Appeal Decision

Appeal Ref: APP/R5510/W/24/3343192

79 Bridgwater Road, Ruislip HA4 0EE

- The appeal is made under section 78 of the Town and Country Planning Act 1990 (as amended) against a refusal to grant planning permission.
- The appeal is made by Robenc property company Ltd against the decision of the Council of the London Borough of Hillingdon.
- The application Ref is 2708/APP/2024/16.
- The development proposed is for a double-storey rear extension already approved under REF: 2708/APP/2023/2540, Outbuilding already approved under REF: 2708/APP/2023/1832, and the conversion of the existing two-storey dwelling into 2no. self-contained flats, with associated front and rear landscaping, bin store and cycle store.

9 Proposed Ground Floor Plan

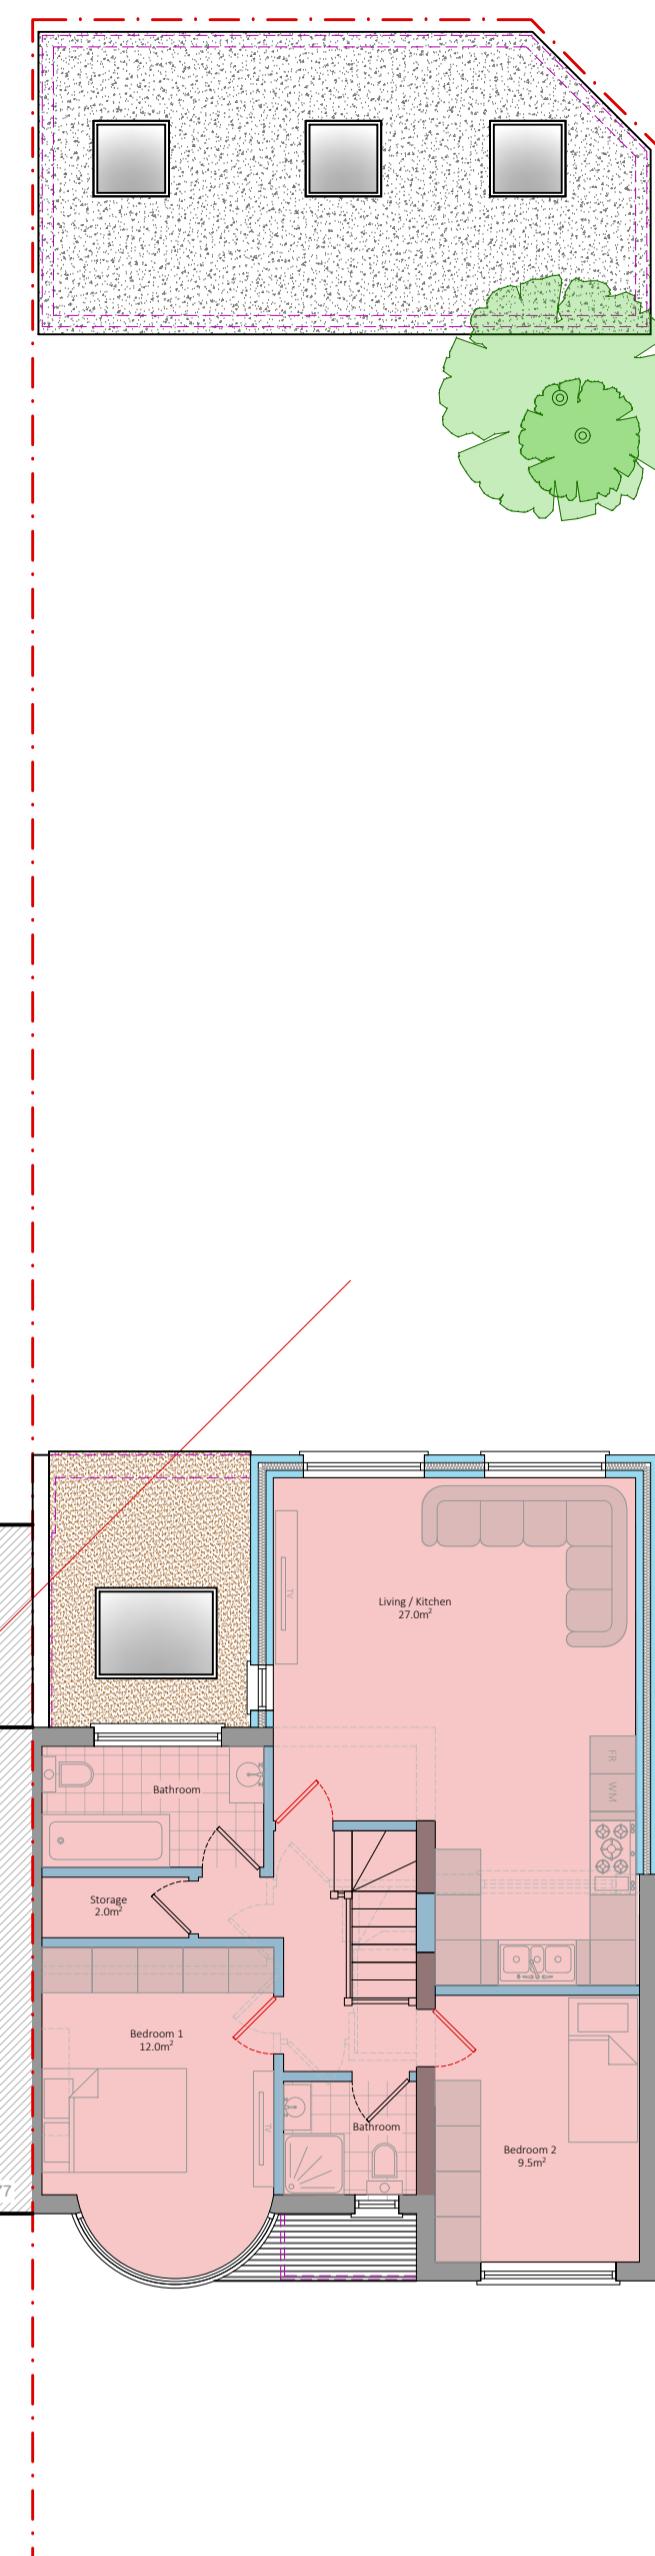
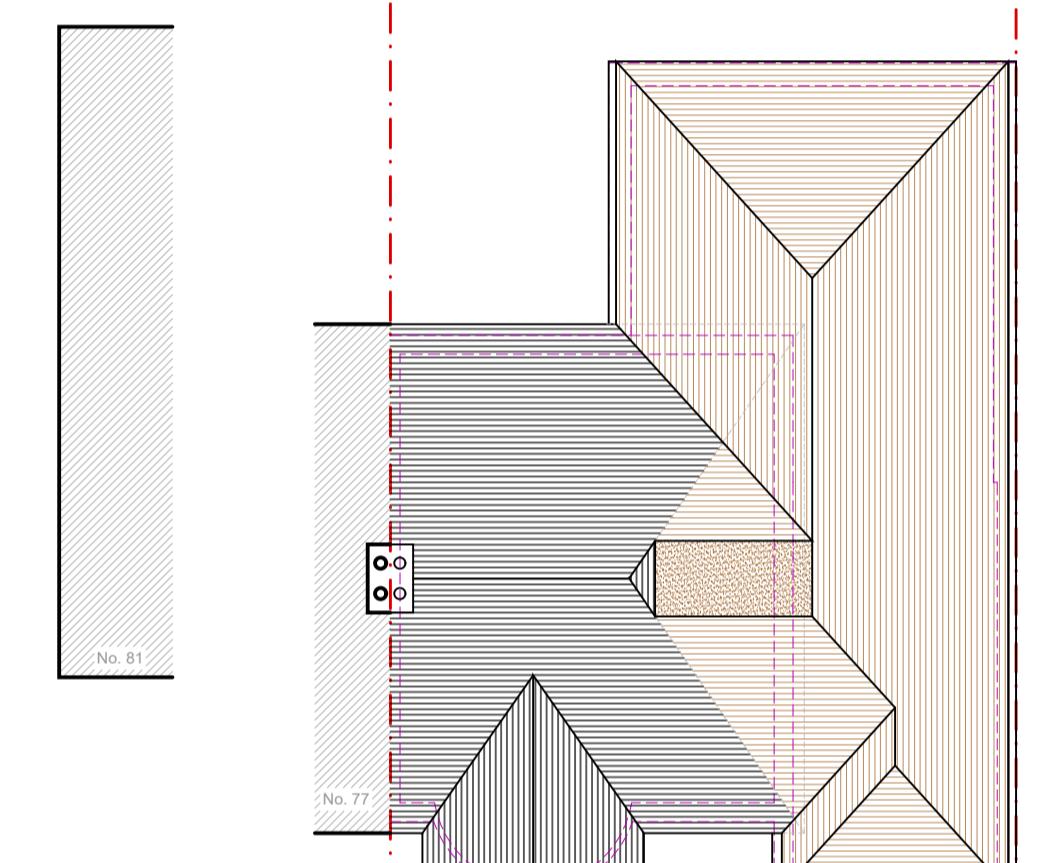
12. The ground floor front bedroom window would be adjacent to the area of vehicle parking and access to the property. Given the quantum of development, I am not persuaded that the overall comings and goings would create that much additional noise and disturbance that it would be unacceptably detrimental to the living conditions of the future occupiers of the ground floor flat.

13. Turning to privacy, the ground floor flat has a large kitchen/living area to the rear, as such the bedroom would be unlikely to be occupied for extended periods of time during the day. While the submitted plans do not specify which flat can park in front of the front bedroom window, I am satisfied if I had been minded to allow the appeal, that this could be dealt with by a condition limiting the car parking to Flat 1. Details of landscaping could also be dealt with by condition, as I consider there is sufficient space to provide landscaping at the front of the ground floor front bedroom window. In coming to this view, I am also mindful of three recently approved applications provided by the appellant, where a similar bedroom arrangement adjacent to a front parking area has been deemed acceptable.

14. The submitted plans detail that the provision of garden space would be significantly above the minimum requirement of 25 square metres as set out in Policy DMHB 18 of the DMP. Whilst access to the garden space for the first-floor flat is less convenient than the ground floor flat, the distance and gated access would not be so onerous as to be prohibitive. The submitted plans show that the boundaries of the two amenity spaces would be demarcated by a 1.8 metre boundary fence and as such would provide a sufficient amount of good quality, usable external amenity space that would ensure adequate privacy for the occupiers of both properties.
